CITY OF MERCER ISLAND

RE: SUB19-002/SEP19-005 – Proposed Preliminary Plat
2825 W. Mercer Way, APN 2174502425
Request for Additional Information, Second Review

The City of Mercer Island Community Planning & Development Department has completed a second review of the application materials submitted on July 13, 2021 for compliance with the Mercer Island City Code (MICC) for the above preliminary long subdivision application.

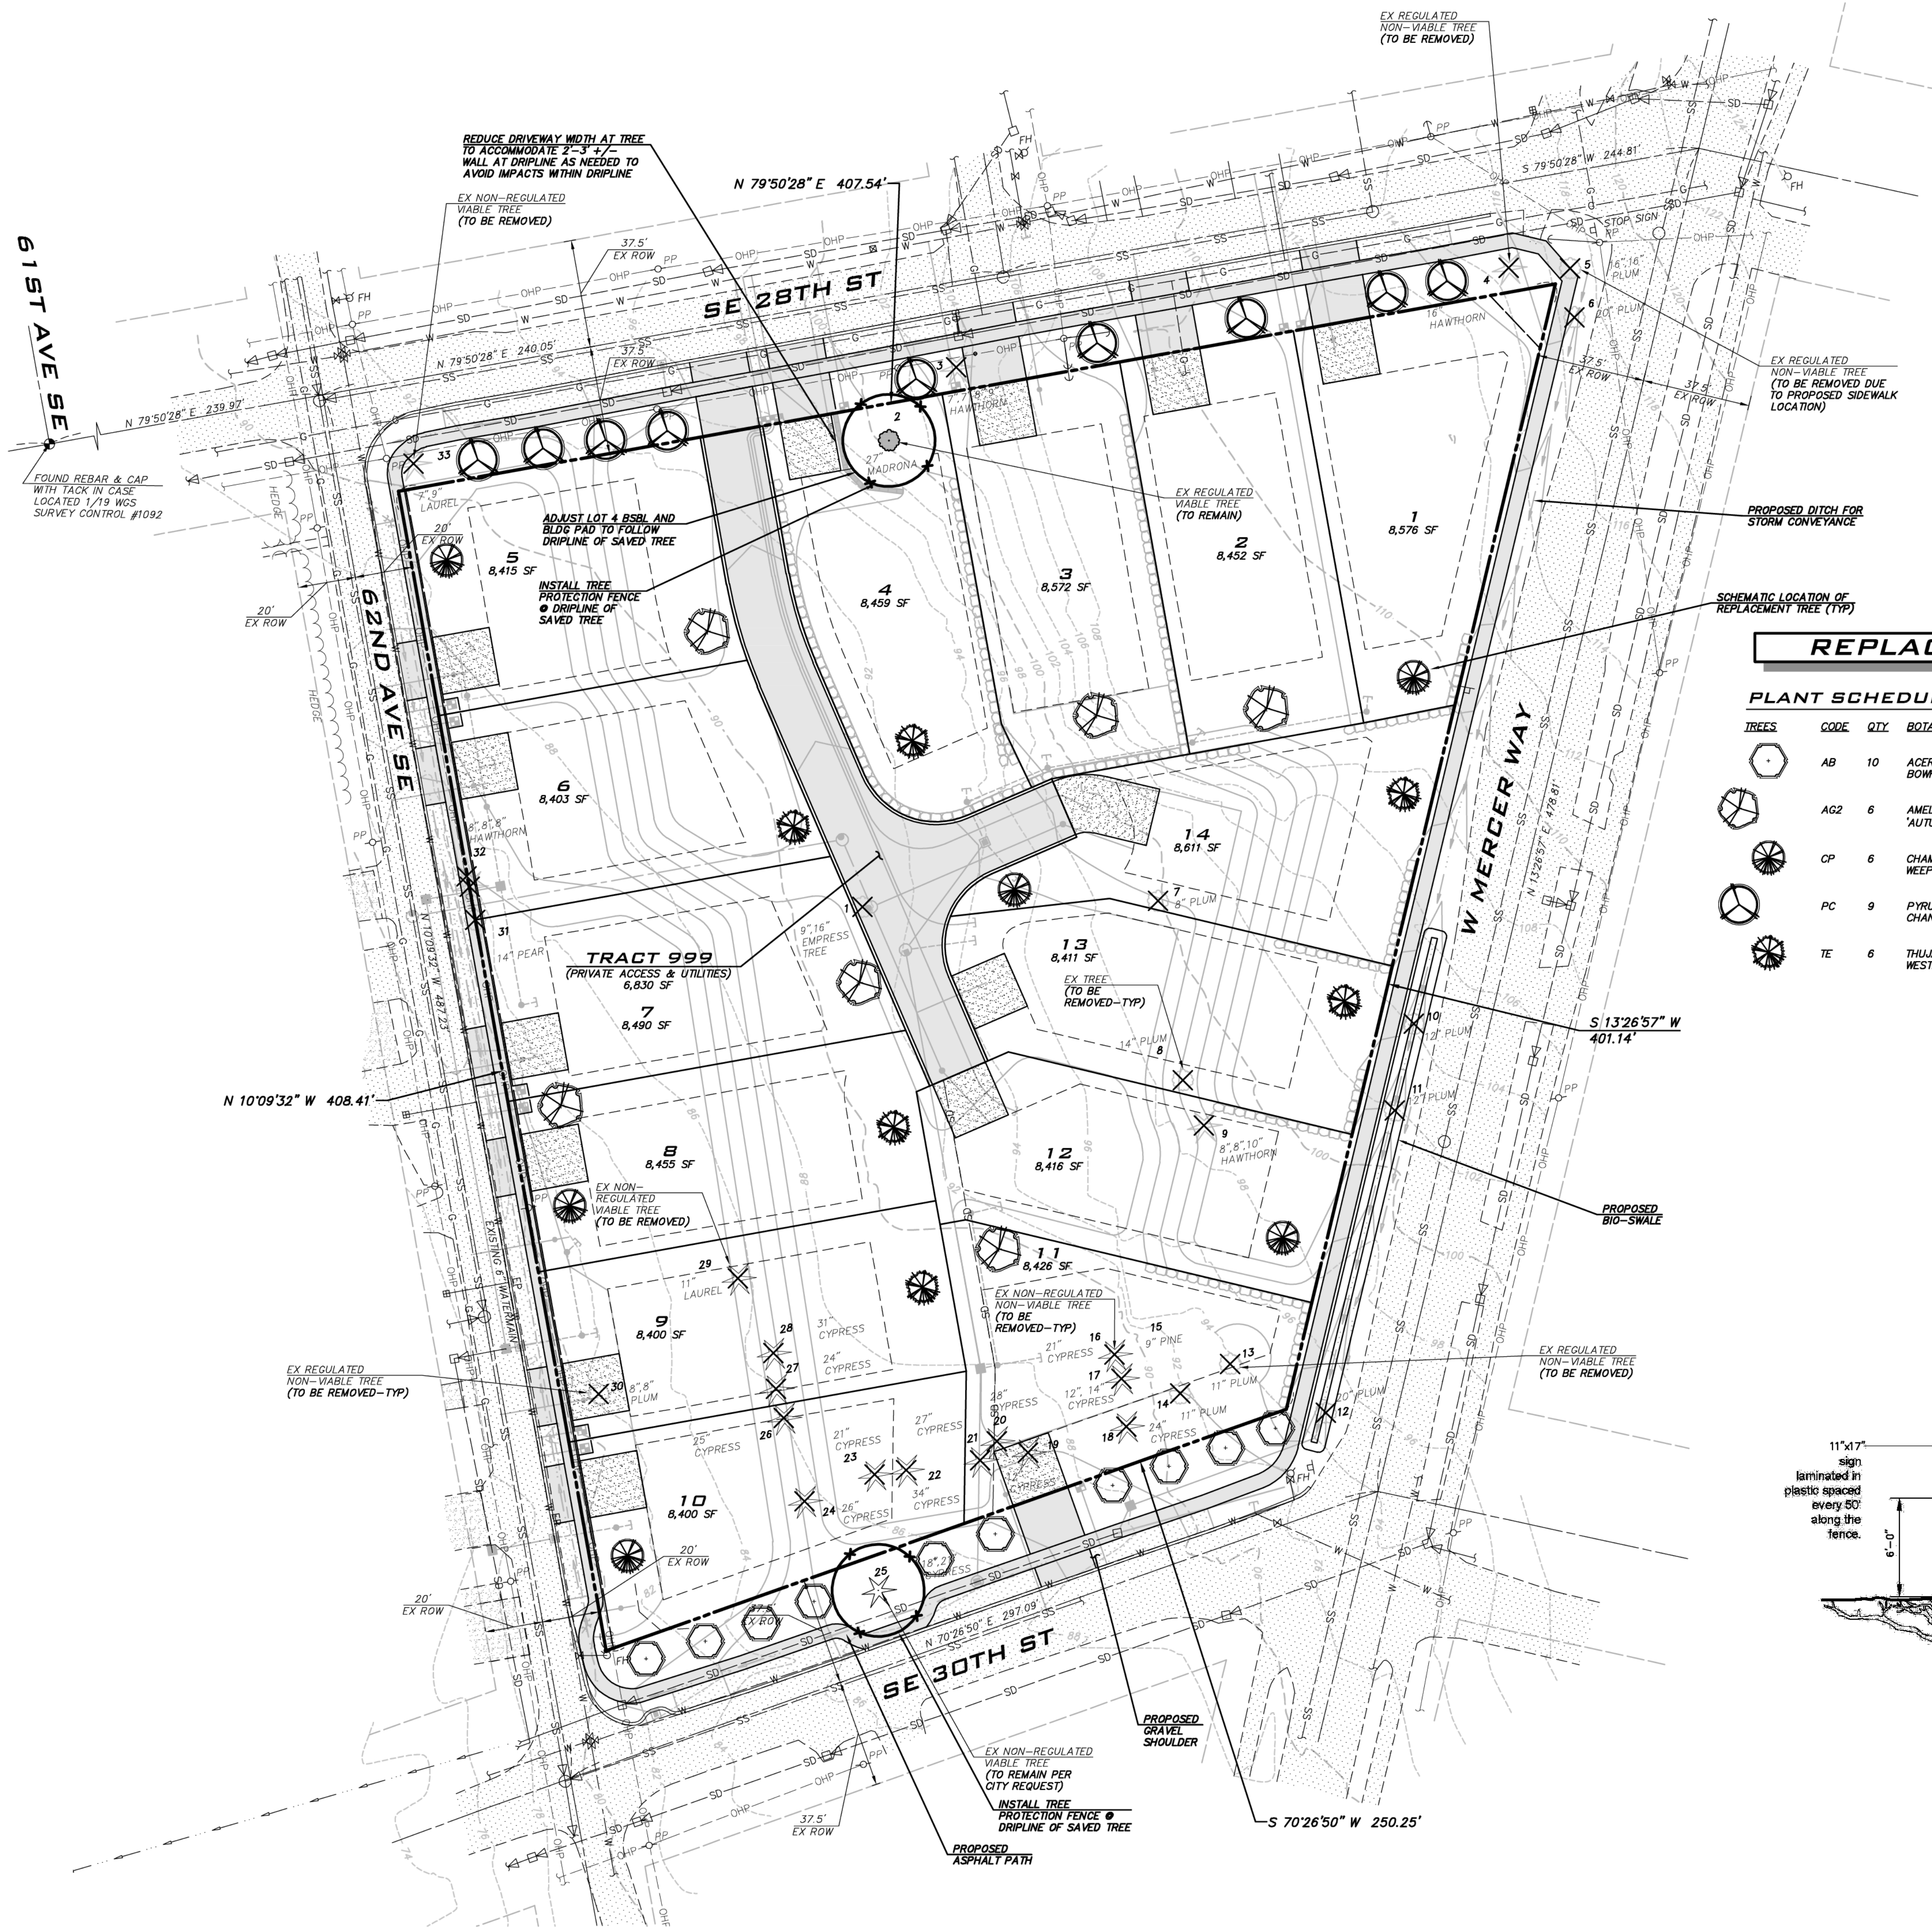
1. A new wall not shown in Sub 1 looks to be within the tree protection zone. The construction of the wall is shown encroaching into the tree protection zone. Place this wall with enough room to construct without encroaching into the tree protection zone. As suggested in a Planning comment a longer driveway would resolve this issue.

2. Show tree 2 protected at 16' and call this out. Building pad, driveway, grading and wall to be shown outside that limit with enough space to reasonably construct building. This means showing at least 5' of space between building pad and driveway in addition to the 16' of protection.

- a. Chainlink fence shall be used to protect saved trees at their dripline, call this out on those plans.
 - b. Update the replanting plan to show trees on city property moved onto the property line so they will be shared trees. Confirm they are at least 10' away from any existing/new

utilities. The pear and red maple on the property line will be replaced with the following species that are less invasive/overplanted.

- c. Plant Regal Prince® Ware's Oak (Quercus x warei 'Long') or similar approved equal on SE 30th instead of the pear.
- d. Replace Bowhall maple with Acer rubrum 'Frank jr' Redpointe maple or similar approved equal on SE 28th St.
